Corrections Narrative

Houtchens Residence

4-3-2023

CA022-017 (Andrew Leon)

SHEET NO.  
**L2**

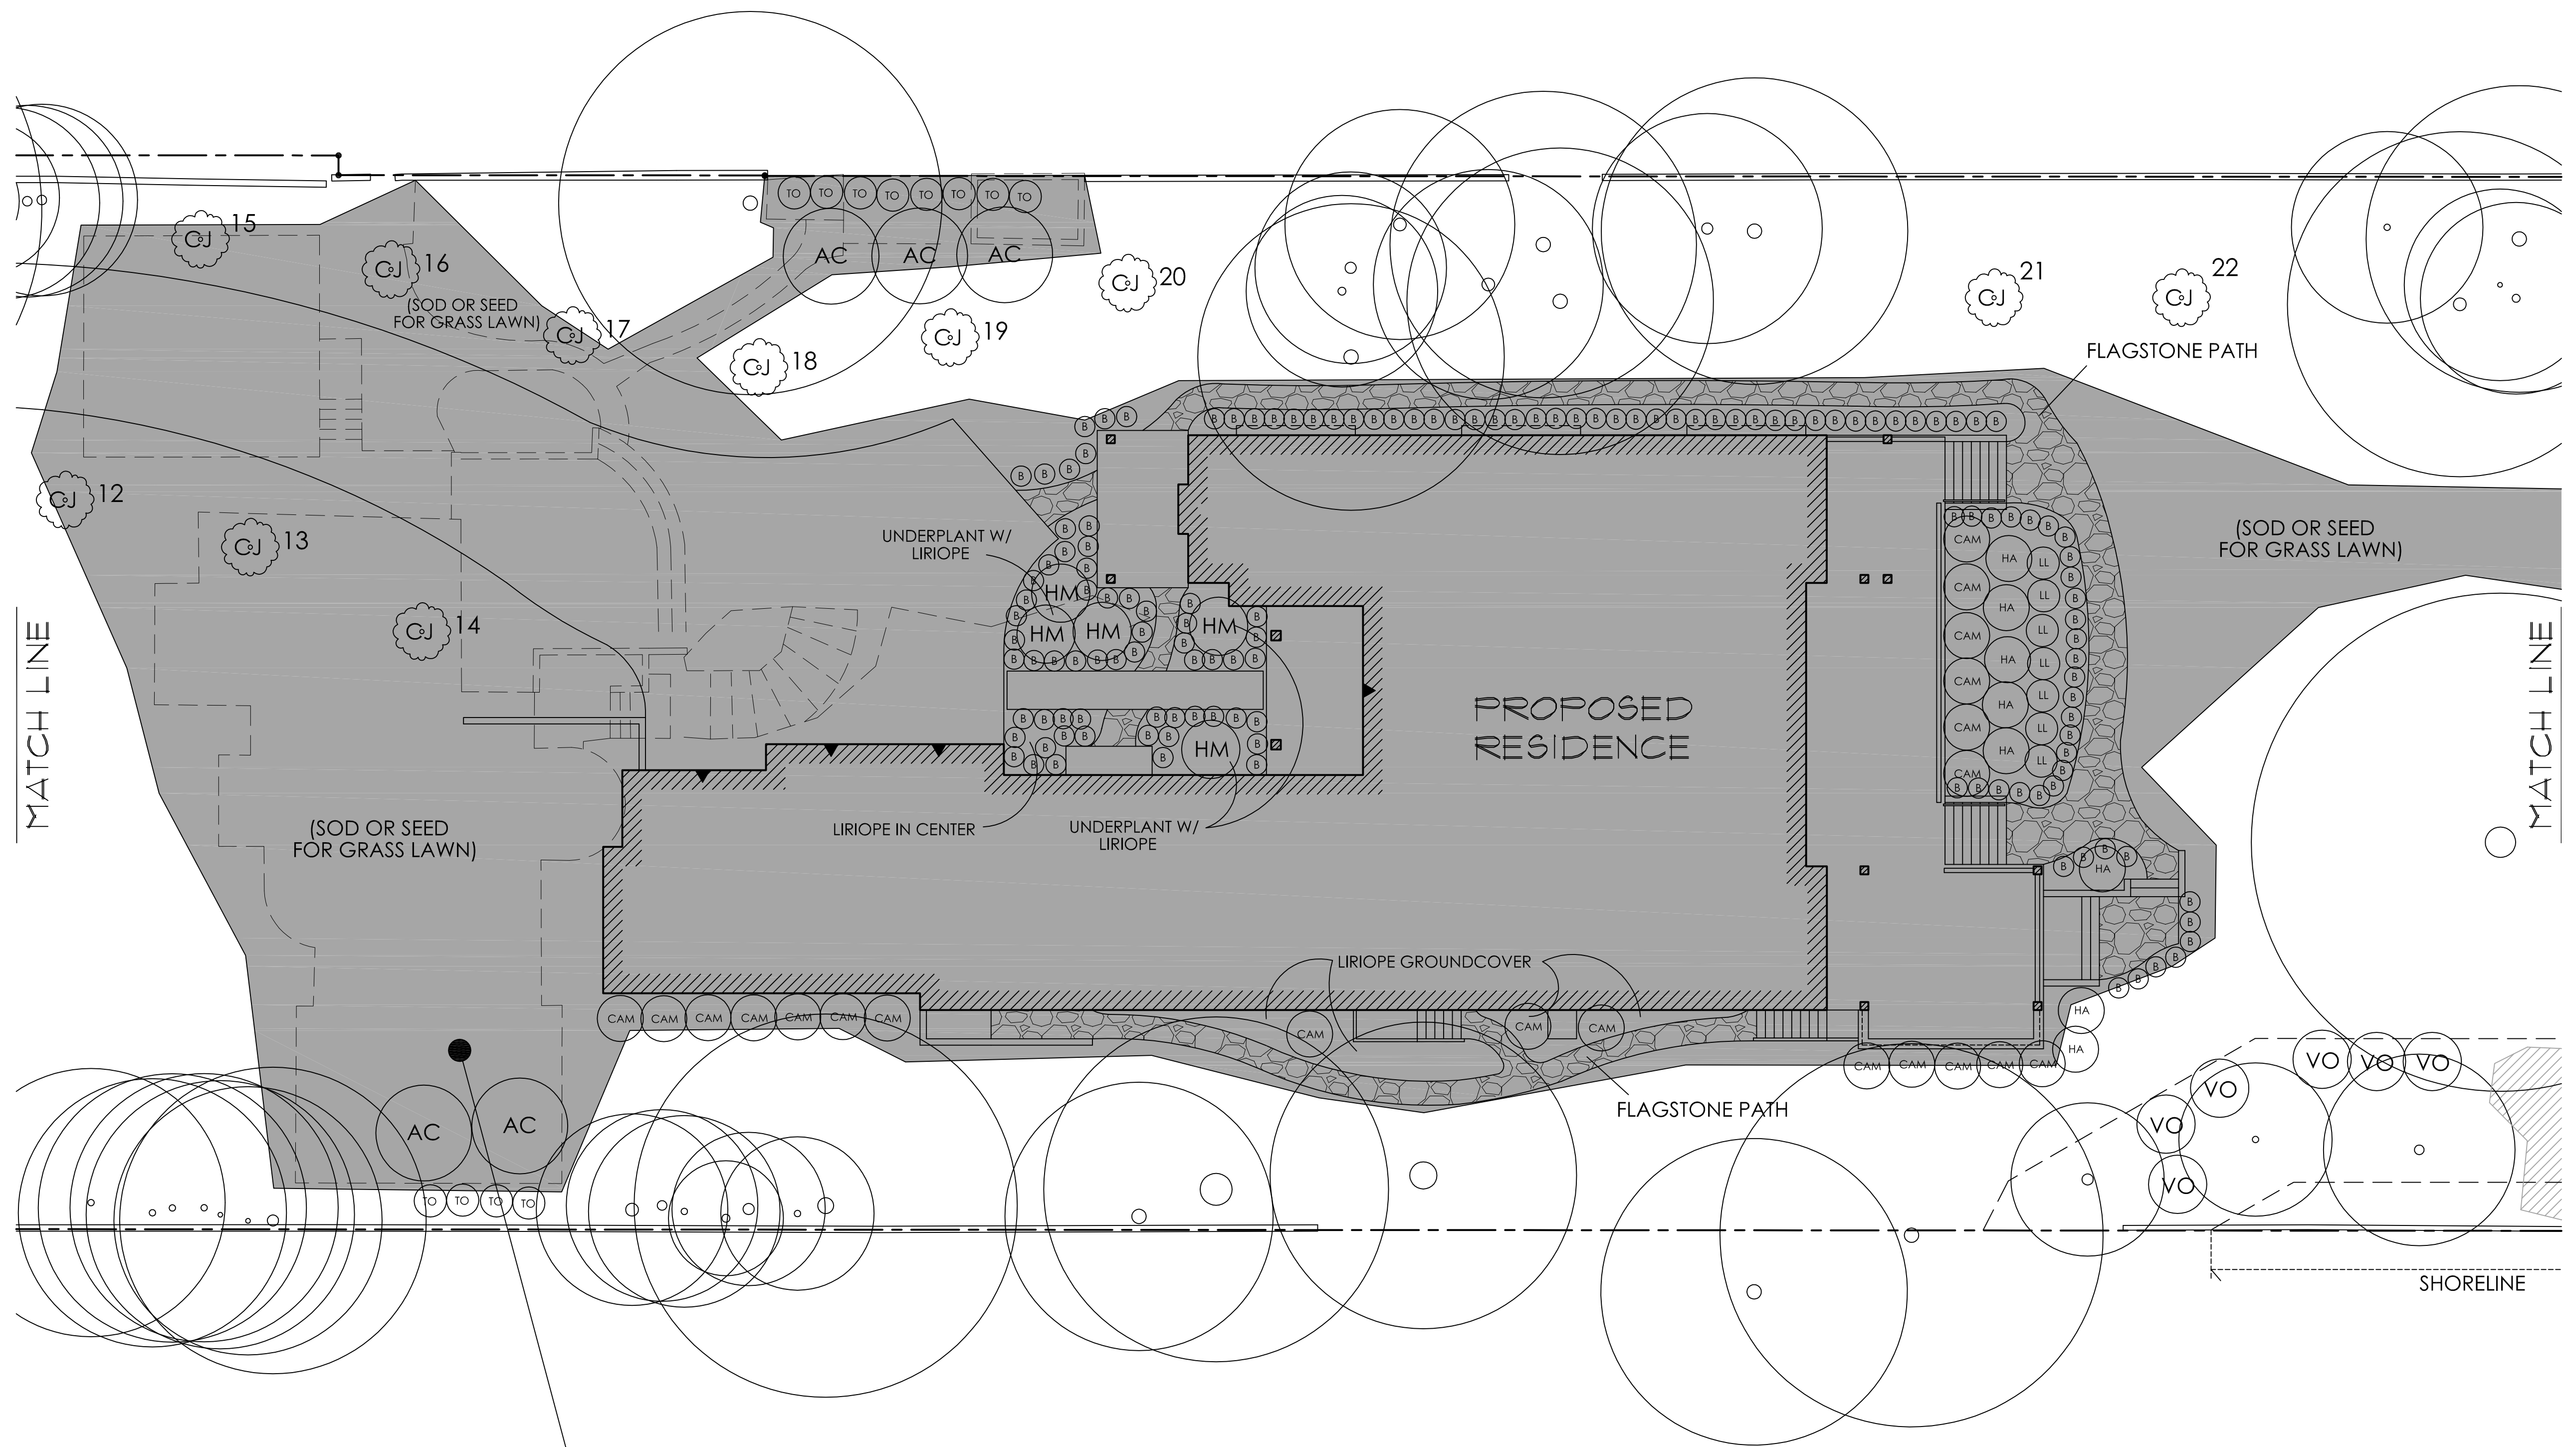
See revised sheets L1, L2, and L3 now showing greater detail for restoration planting surrounding new construction and building removal areas.
